5 August 2010

Our Ref: E6102.1\_It

**RE: Issues raised by Department of Planning and Tweed Shire Council relating to the proposed tourist resort at Casuarina Way, South Kingscliff**

DRAWING SET DRAWING TITLE: MAINTENANCE AREA FLOOR PLAN & MODEL VIEW
 DRAWING No: 1040 MA-04-1
 ISSUE: A
 PRINT DATE: 2/04/2009

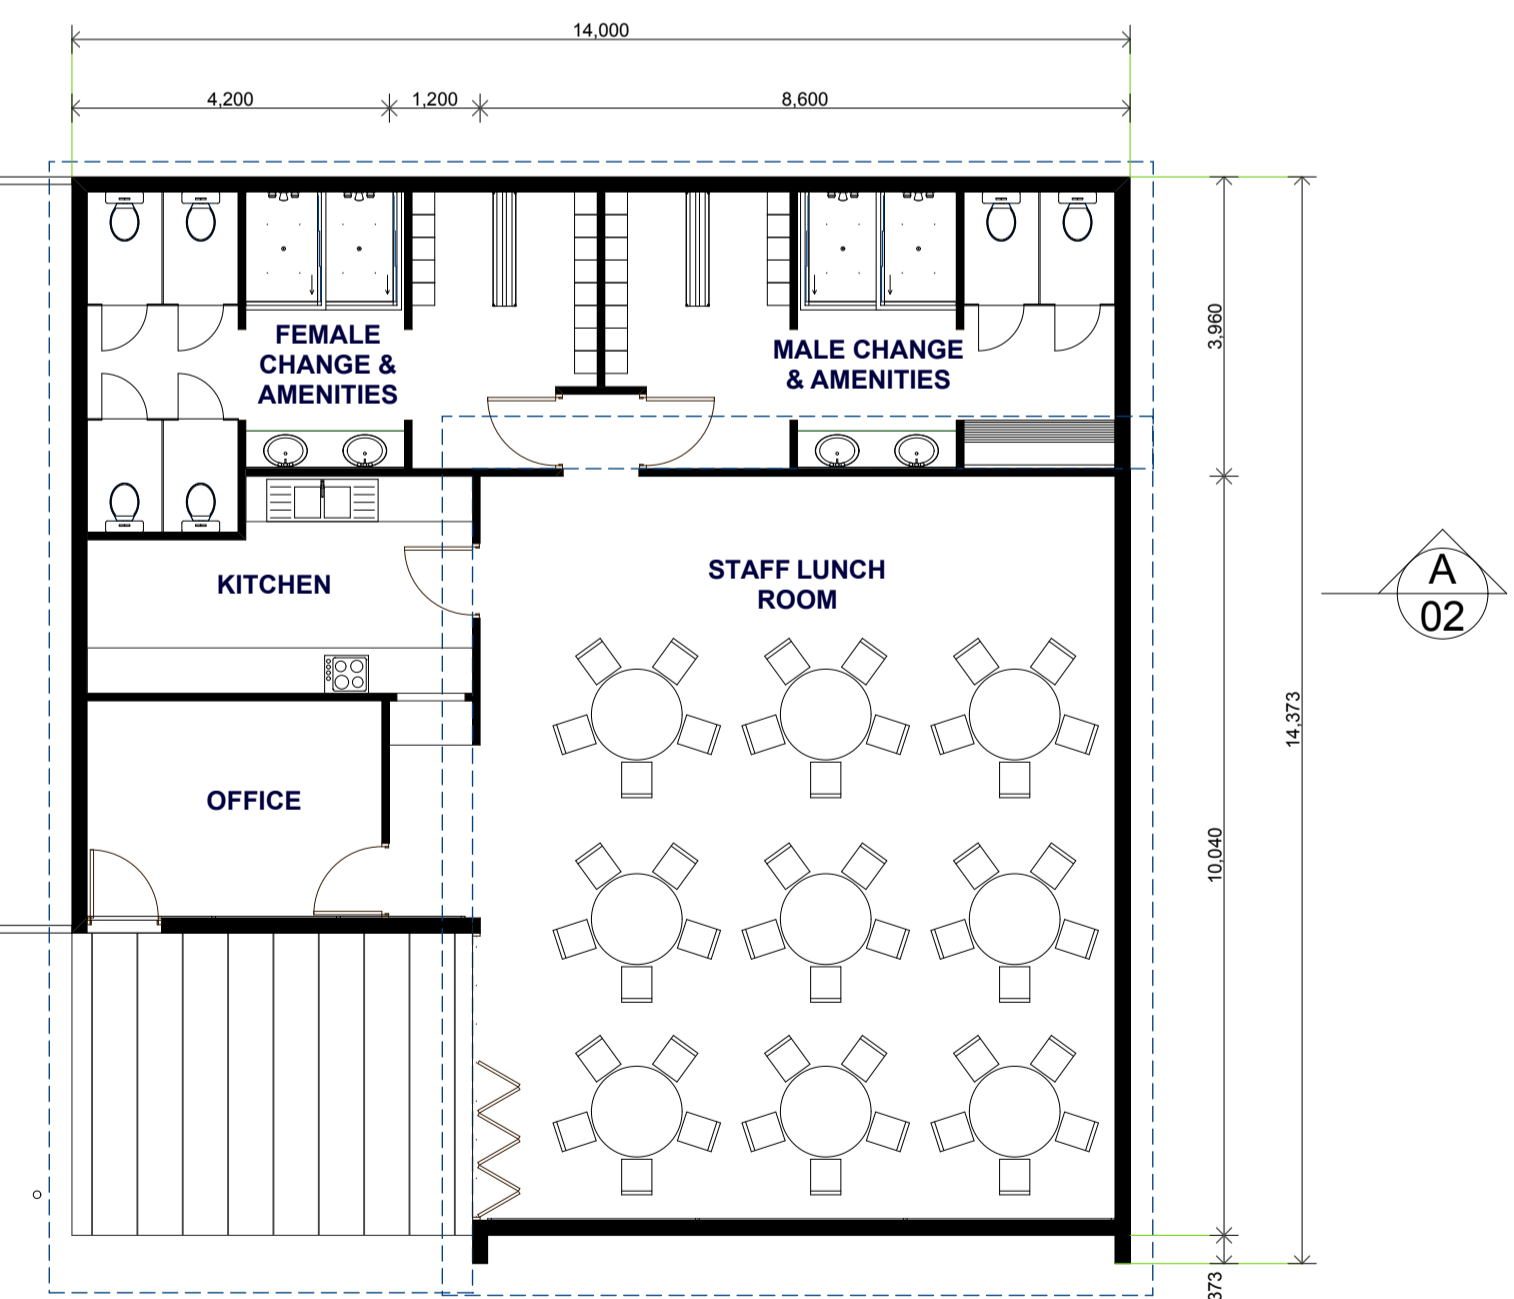
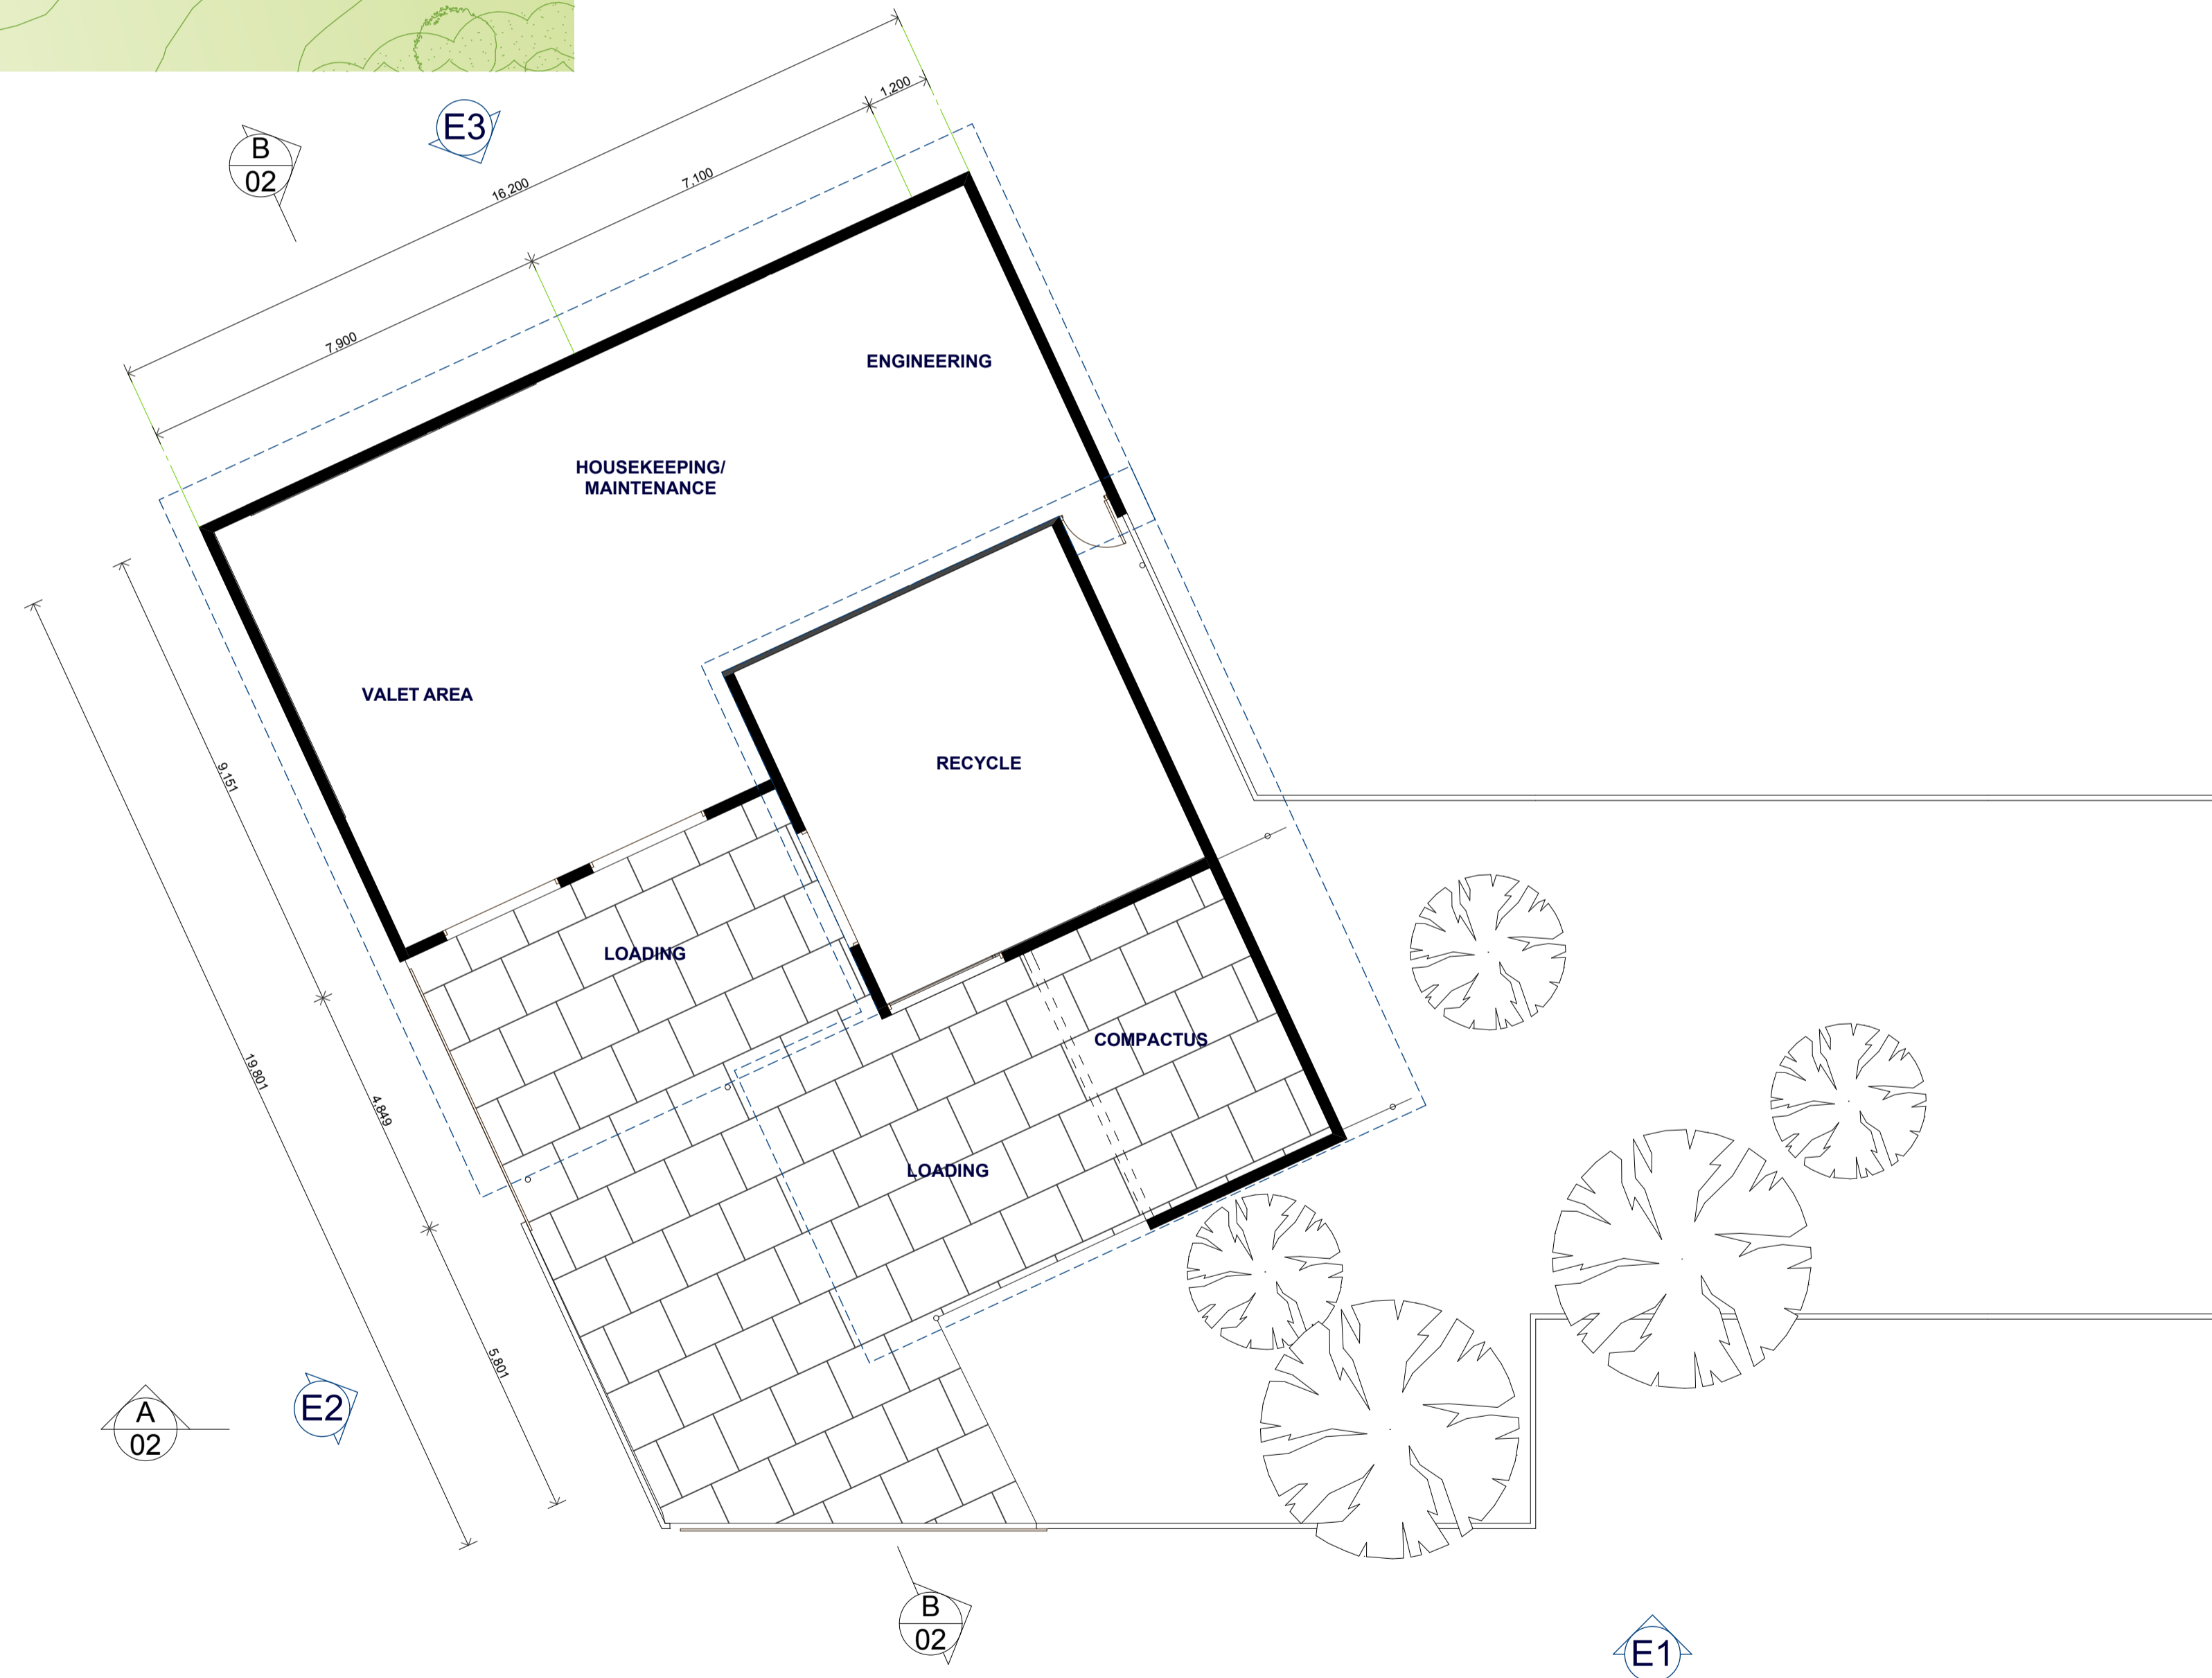
*There is concern regarding the potentially poor visual appearance of the proposed car park areas (southern end) when travelling along Casuarina Way.*

However, as noted in Council's comments, there would be more built form and carparking visible near the south-east corner of the site, where the proposed Maintenance Area is located. The photomontage we had prepared for this area revealed the following:

- the proposed landscaping would screen much of the maintenance building and carparking areas;
- this screening would be augmented by the visually recessive screen fencing proposed along the resort site boundary;
- a vegetated skyline would remain in the background of the view, thereby maintaining the dominance of the natural elements over built form; and

I note that, since our photomontages were prepared the plan of layout has changed to expand the southern buffer zone in the vicinity of the Maintenance Area from approximately 15 metres to 30 metres, consistent with the rest of the buffer. The effect of this will be to increase the buffering potential between the Maintenance Area and Salt residences along the southern boundary, and to increase screening of the Maintenance Area when viewed from Casuarina Way. Whilst I was of the opinion that the previously proposed scenario constituted an acceptable visual outcome, this amended layout will significantly increase the screening of the Maintenance Area, and greatly reduce the potential visual impacts, representing a far superior visual outcome.
